Site Plan Conditions of Approval re 1342 Congress JCA Building

Jean Fraser <jf@portlandmaine.gov> Tue, May 17, 2016 at 2:22 PM

I have not heard from you or your team recently about addressing the Planning Board's conditions of approval as set out on the attached letter (Conditions under C. Site Plan #s i-vii) which all should be addressed prior to the issuance of a building permit. I am not sure who is the correct "contact person" re the site plan so I have copied this e-mail to the several names listed on the applications. Please send any plans and documents to address the conditions to me and I will arrange for the final reviews by my colleagues as appropriate.

SCALE: AS SHOWN
 C-2B

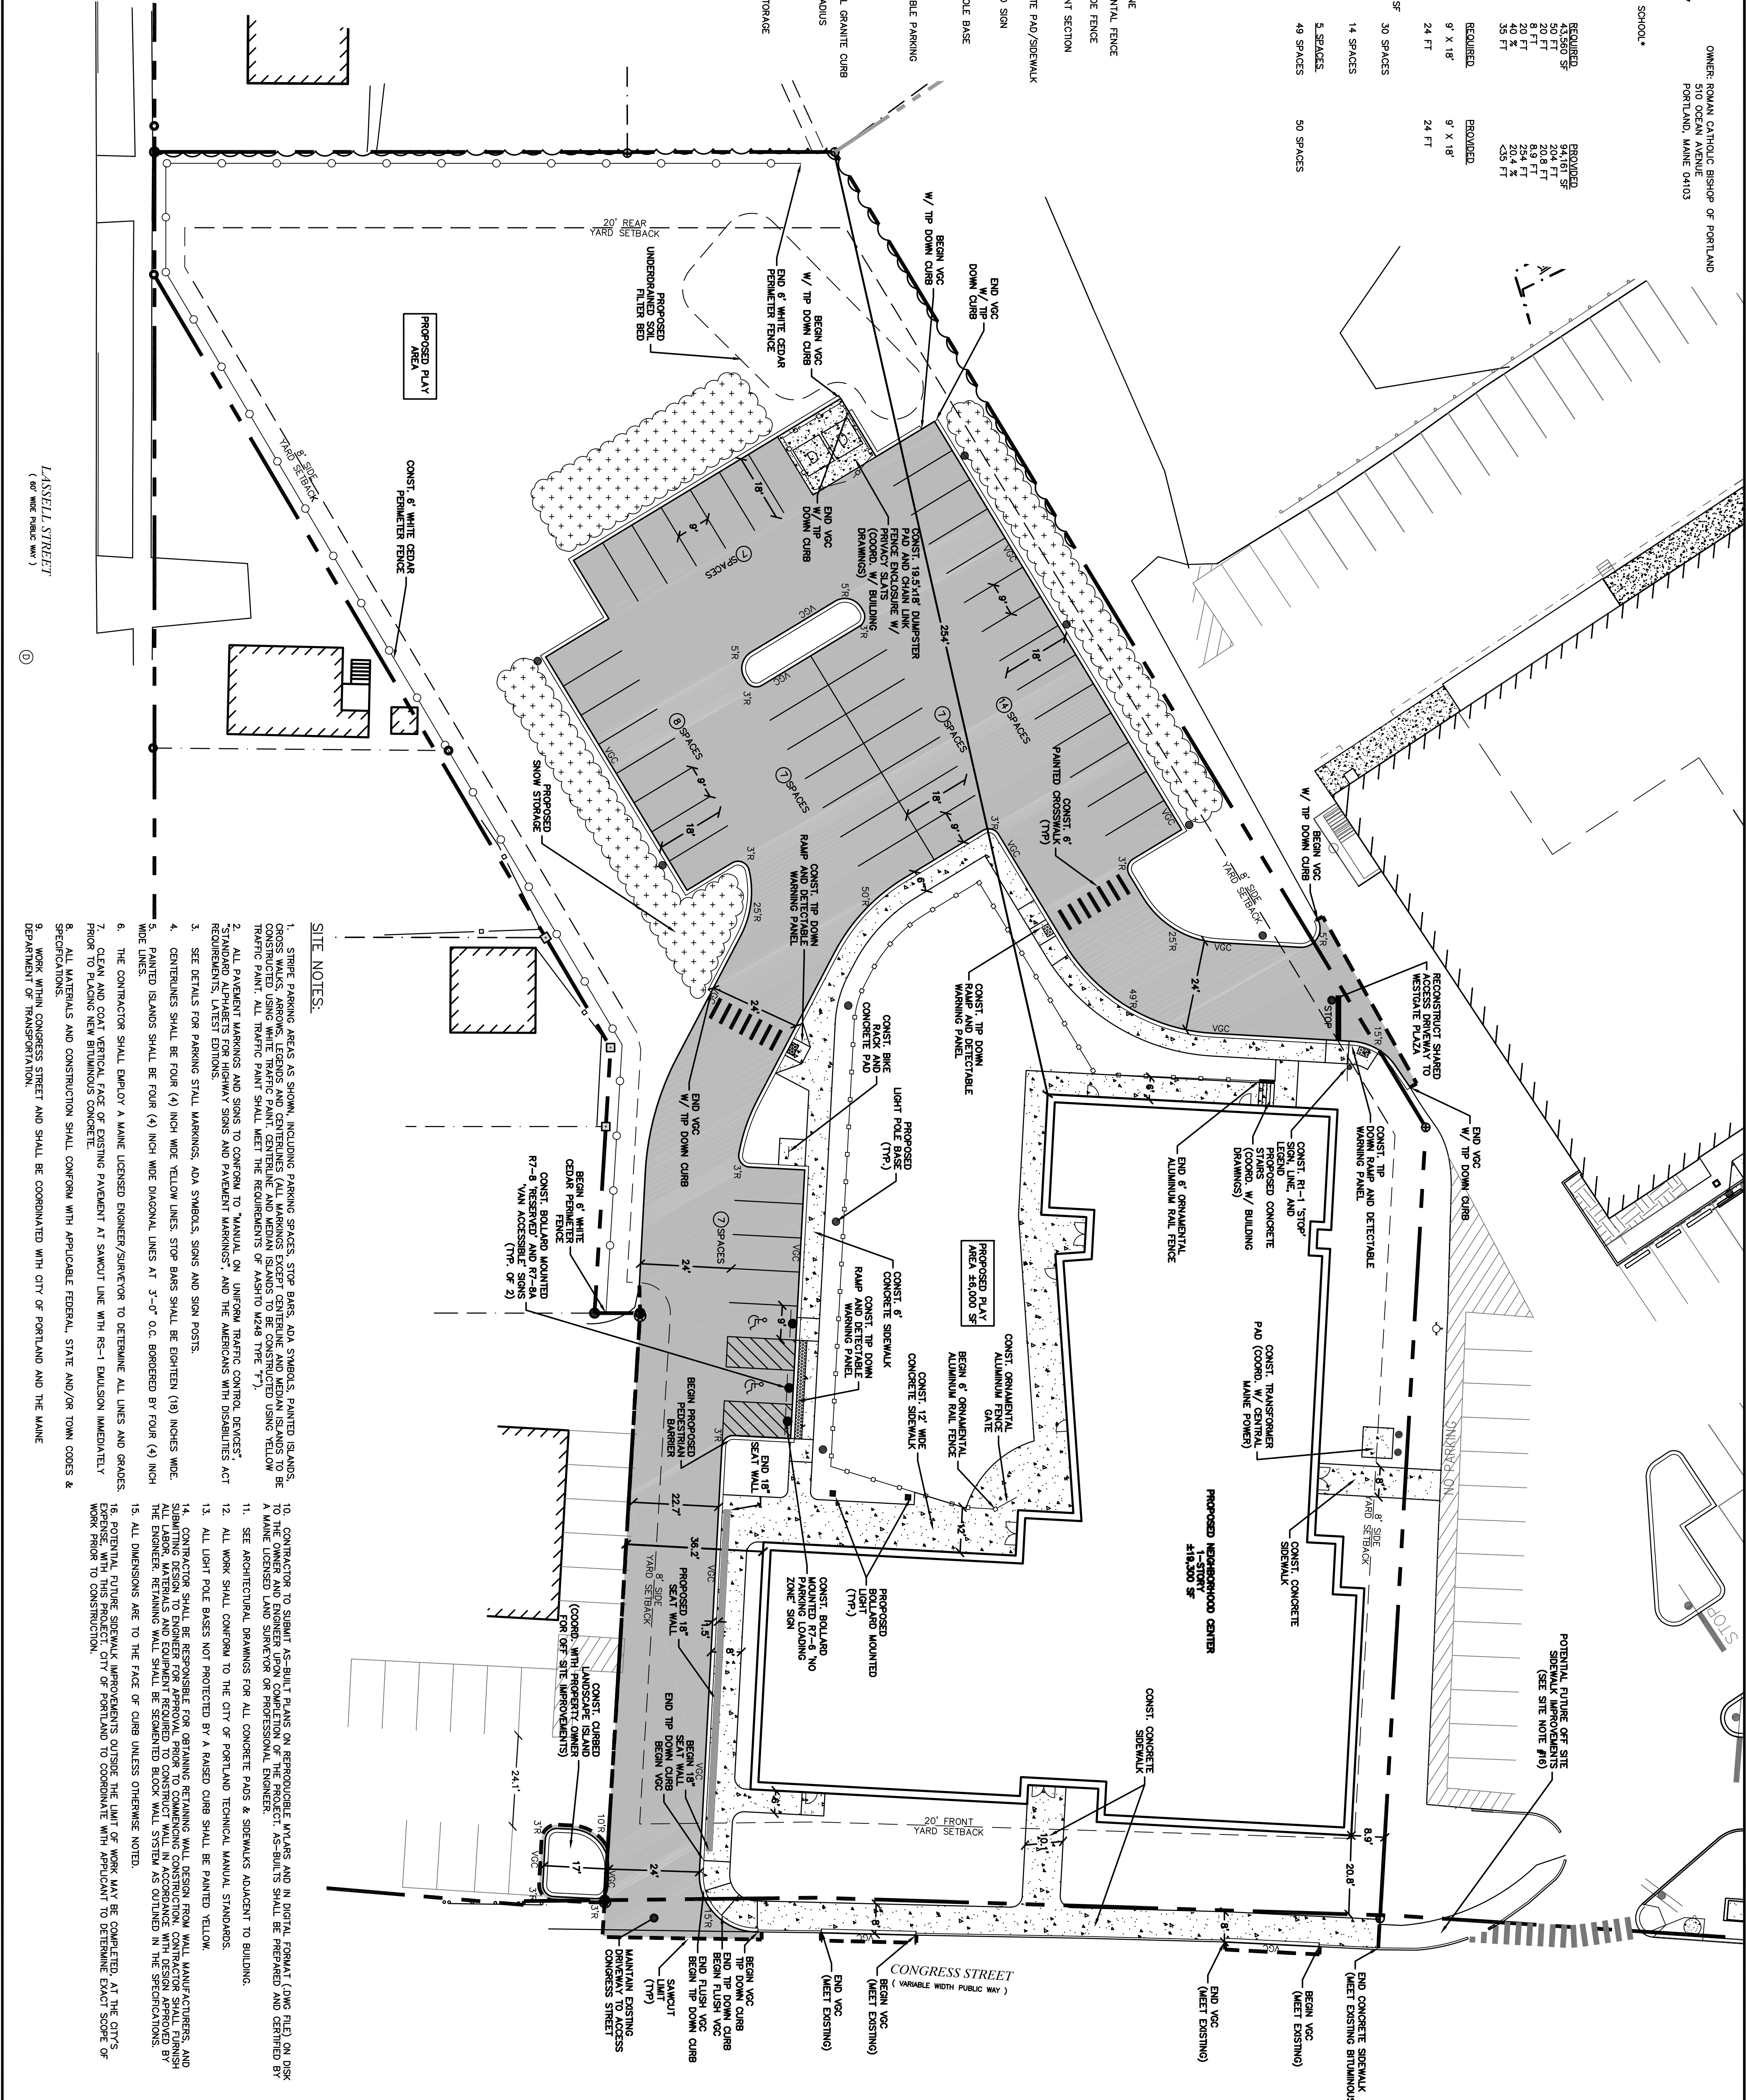
Regarding condition iv that relates to the perimeter white cedar fencing (see attached approved site plan), I sent the attached e-mail to Greg Halsey in January 2016 after investigating this question with both the abutter and the City Arborist, Jeff Tarling. The final resolution (which needs to be shown on a revised site plan) is that the white cedar perimeter fence should be **5** feet high (not **6** feet) at least along the back yards of the houses on Lassall Street. I believe that the 6 foot spec was originally suggested by Jeff Tarling, and he has now revised his suggestion to 5 feet with a tapered end (see suggestion in photo) at the end nearest to Congress Street. This seems much more appropriate and I hope this is not a concern for you-- it will be cheaper!
